From: Amanda Scholes on behalf of Planning.Responses
Sent: 02 December 2020 11:04
To: Planning Scanning
Subject: FW: P/97/20/PL- Land To North Of Summer Lane Pagham

WSSC Surface Water Drainage Consultation response to add to Ocella/Ccubes.

From: Kevin Macknay [REDACTED]
Sent: 01 December 2020 16:02
To: Paul Cann <Paul.Cann@arun.gov.uk>; Simon Davis <Simon.Davis@arun.gov.uk>; Laura Gibbons <Laura.Gibbons@arun.gov.uk>
Cc: Roger Spencer <Roger.Spencer@arun.gov.uk>
Subject: RE: P/97/20/PL- Land To North Of Summer Lane Pagham

Drawing Title
Proposed Site Plan
105 Unit Scheme

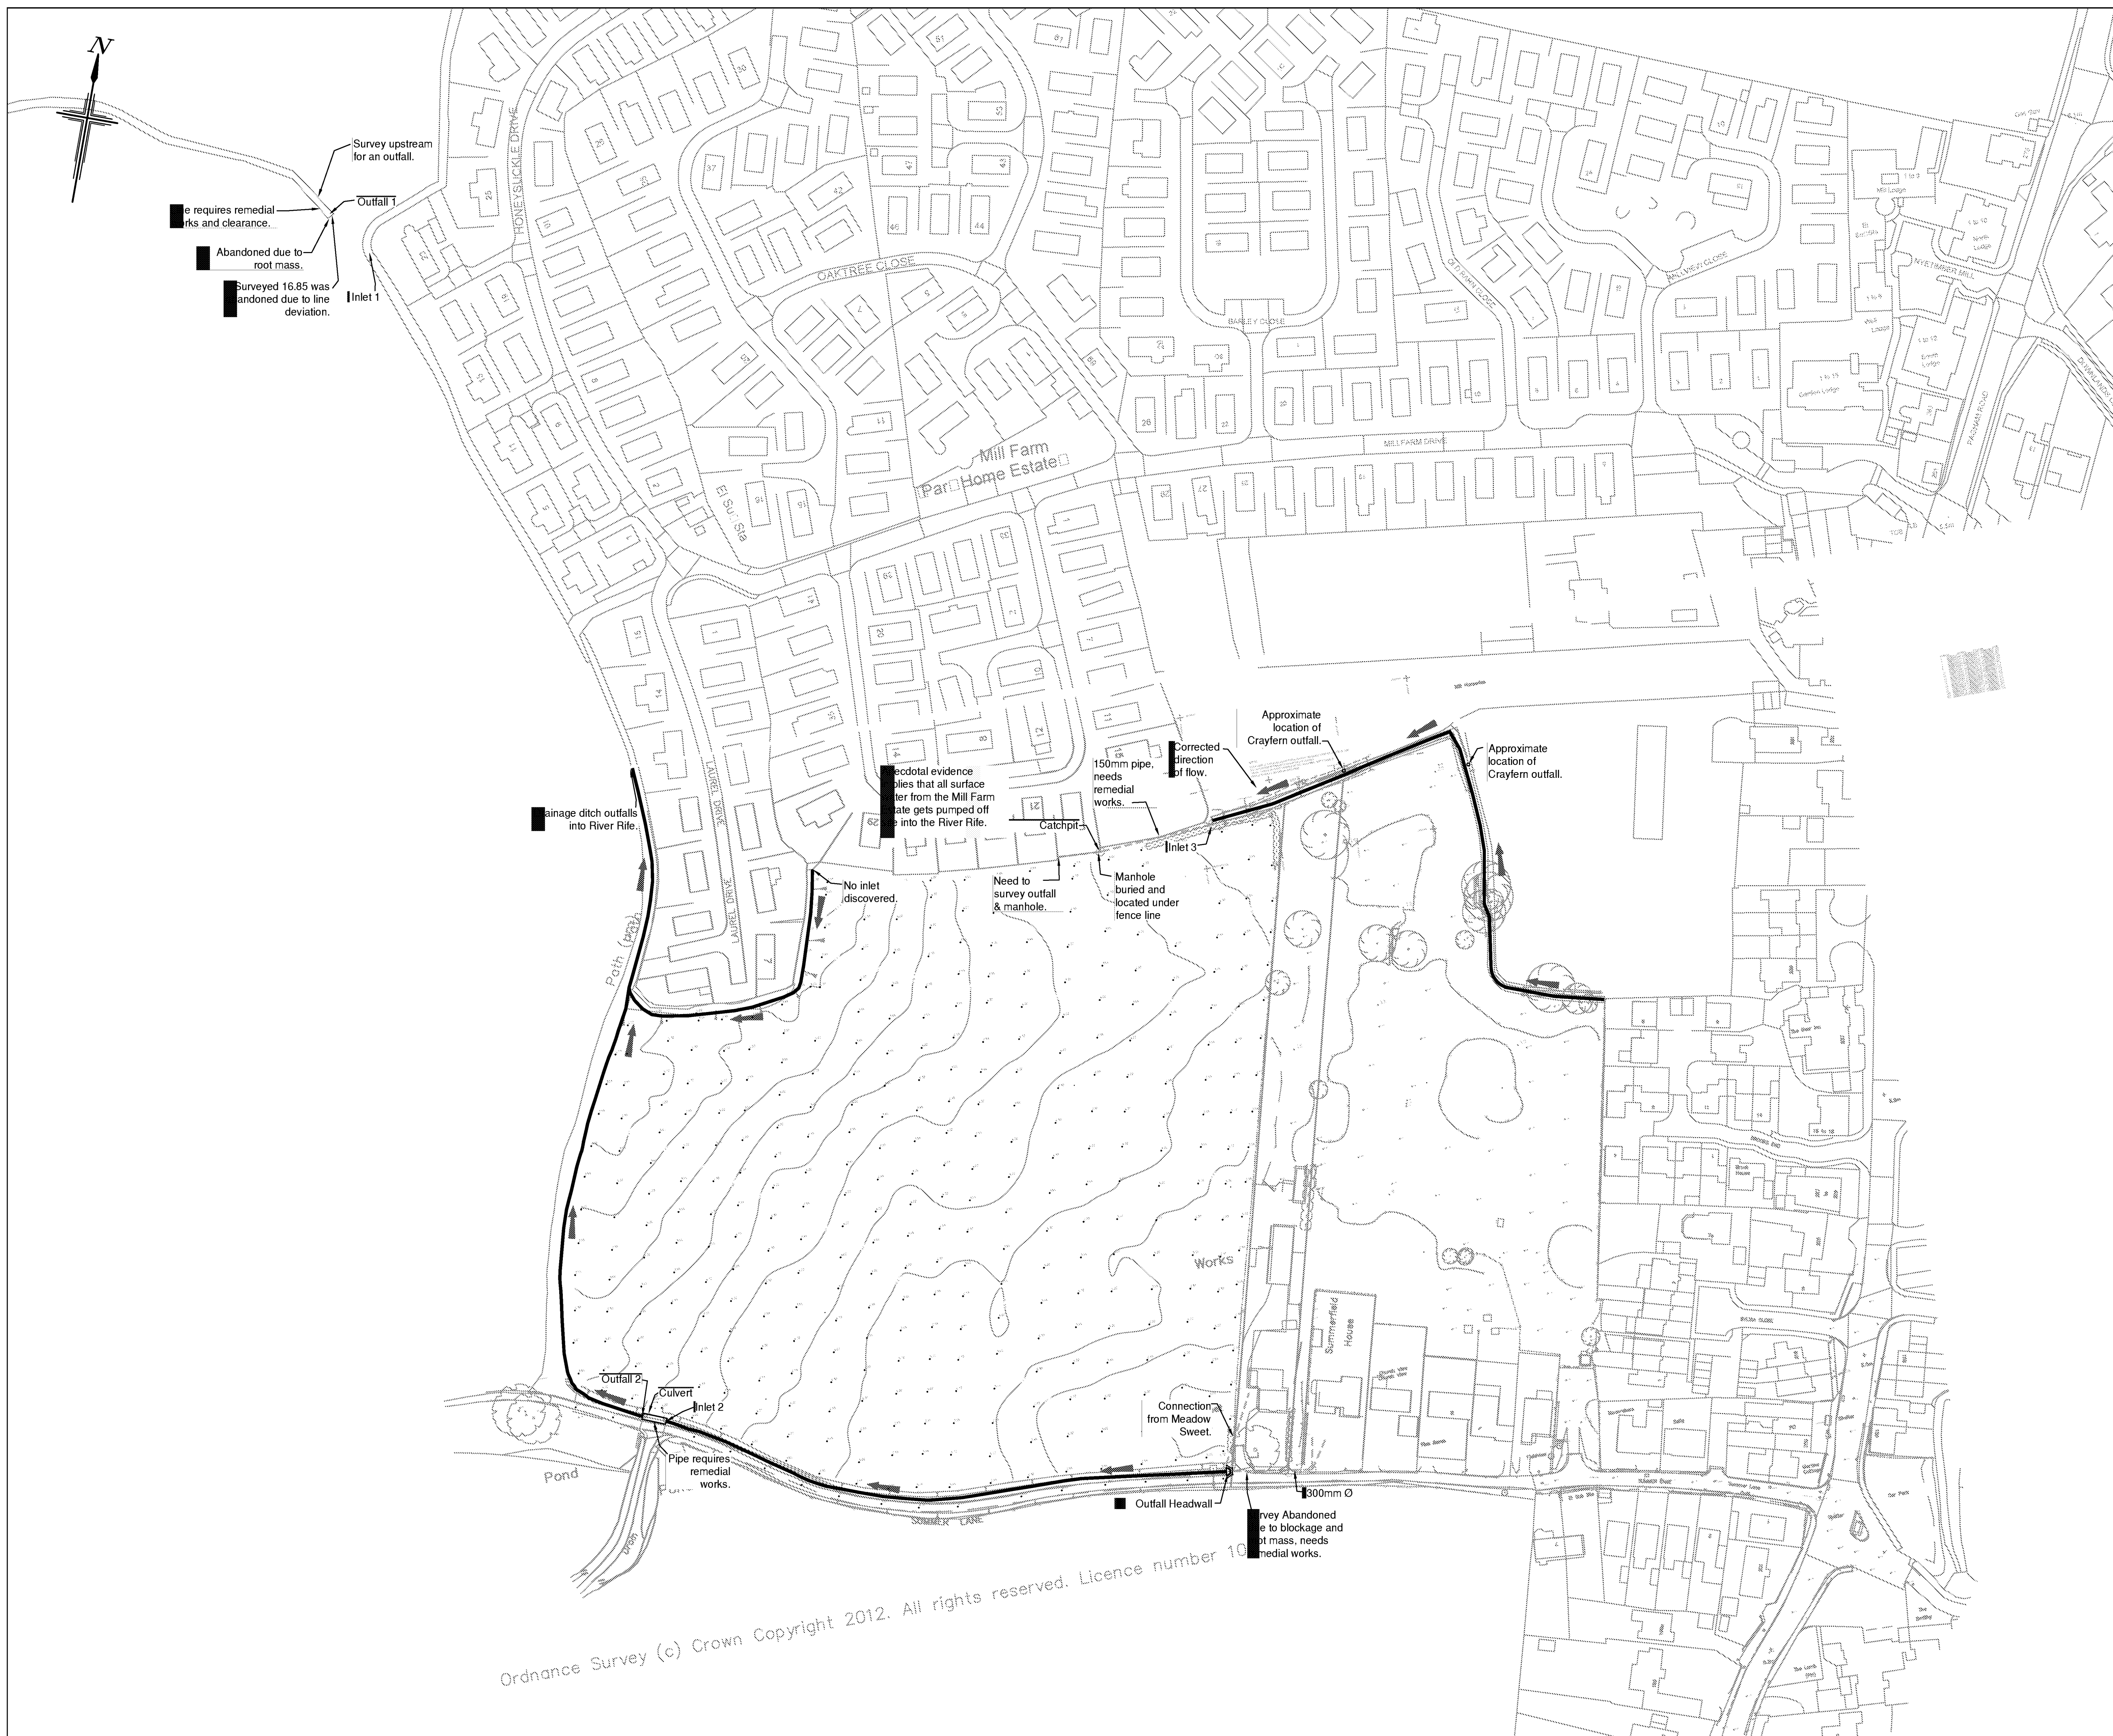
The proposed revised development layout has not been designed in accordance with the WSSC Culvert Policy, which is not in favour of culverting existing open watercourses.

The current proposal will result in around 50m of current open watercourse being culverted. Better consideration to current WSSC policy and a revised layout could have reduced the ecological effects that this proposed development will have on the local ditch network.

I can see that capacity will not be an issue, as the ditch is being increased in size to accommodate the proposed 750mm culverts and it would appear that, in fact, ecology is not seen to be an issue due to the proposed ecological mitigation. Therefore, it would be difficult to object to this proposal.

However, as this culverting goes against our current policy, I believe that the developer should be asked to provide further local improvements within the existing ditch network, to be agreed with Arun DC, to further mitigate to effects of this culverting.
